Charlotte Storm Water
600 East Fourth Street
Charlotte, N C 28202-2844

Rezoning Petition Review

Date of Review: September 24, 2020 (***Revised October 20, 2020***)

Rezoning Petition #: 20-120

REZONING PLAN
RZ.01

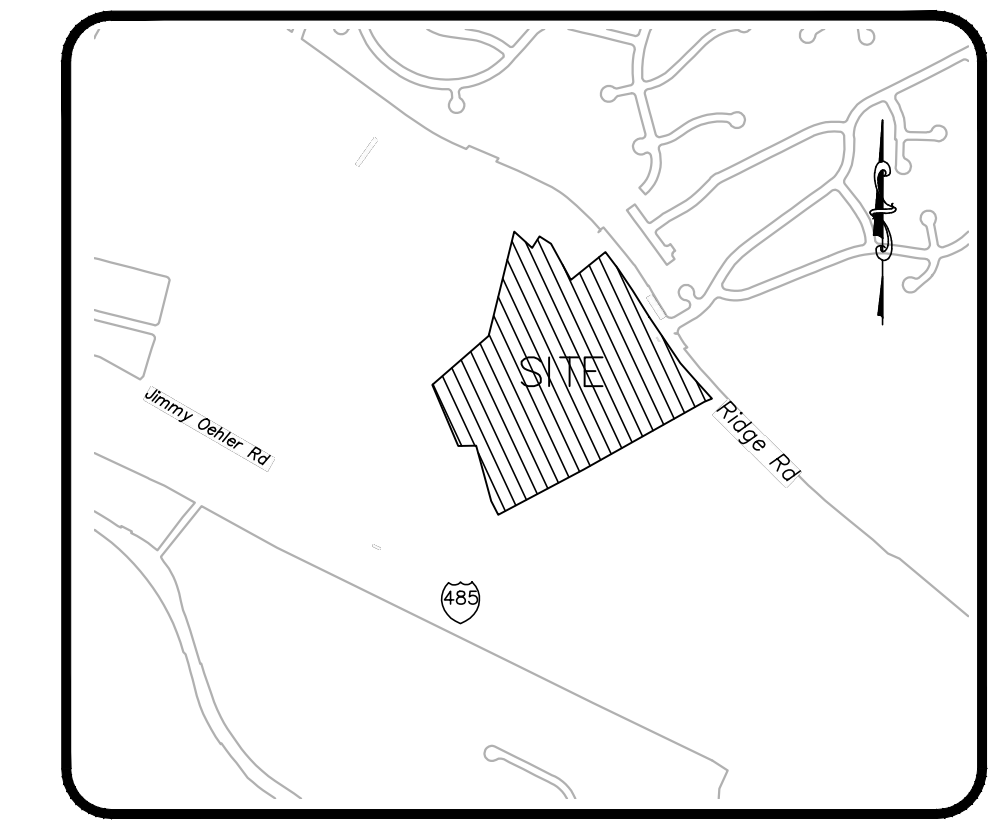
Recommendations Concerning Storm Water: Please clearly map and show FEMA limits on the rezoning plan sheet.
